Our Ref: FG/86/21/DOC

Approval of details reserved by condition imposed under ref FG/105/20/PL relating to Condition Nos 3 - car parking, 4 - materials & finishes, 5 - covered & secure cycle parking spaces, 6 - Arboricultural Impact Assessment, 8 - decentralised, renewable & low carbon energy and 9 - charging of electric vehicles

Tudor Close Public House Ferringham Lane Ferring BN12 5NQ

Arun District Council have decided to **REFUSE details reserved by condition for the following reasons:**

210809.1_R0_003

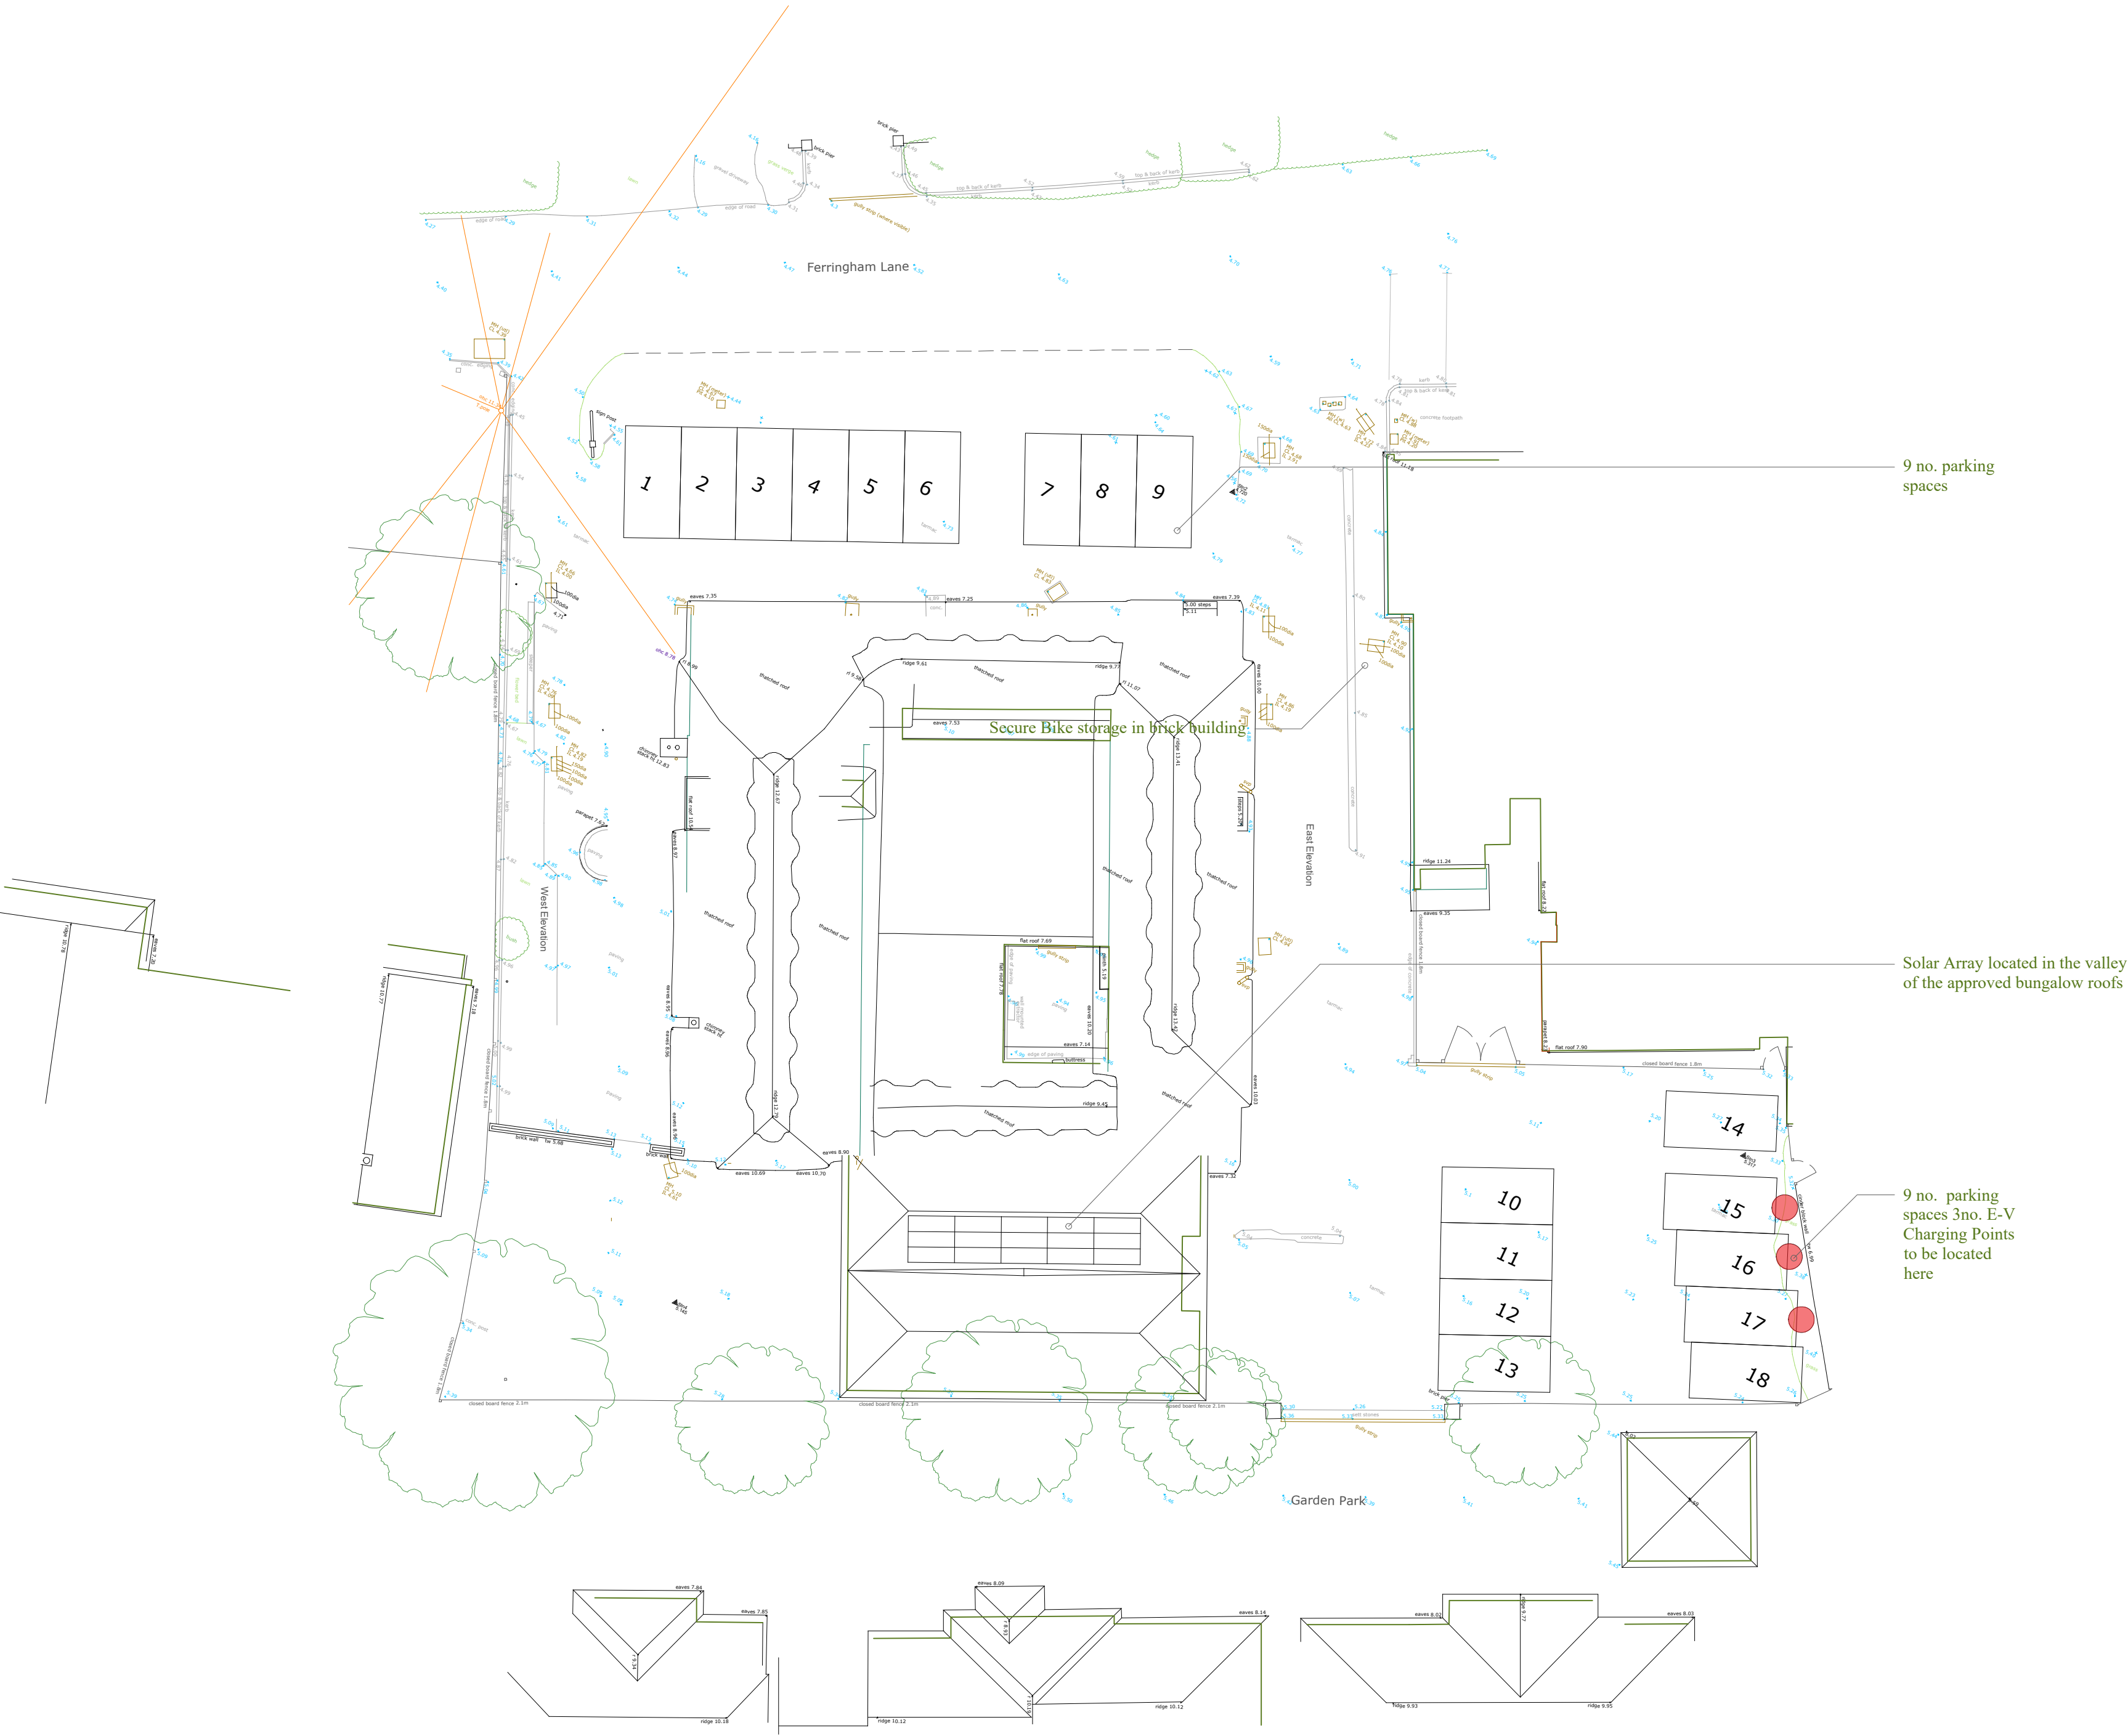
The submitted dwg.no. 2003TU_R1_003 dated 06/05/2021 in respect of low carbon energy supply systems shows a solar array situated on the roofs. This is not considered to be appropriate and would not satisfy the requirements of the condition. The applicant failed to provide Regulation Compliance Report, SAP or Thermal Calculations.

As such, the condition 8 cannot be discharged and you will need to make a revised submission.
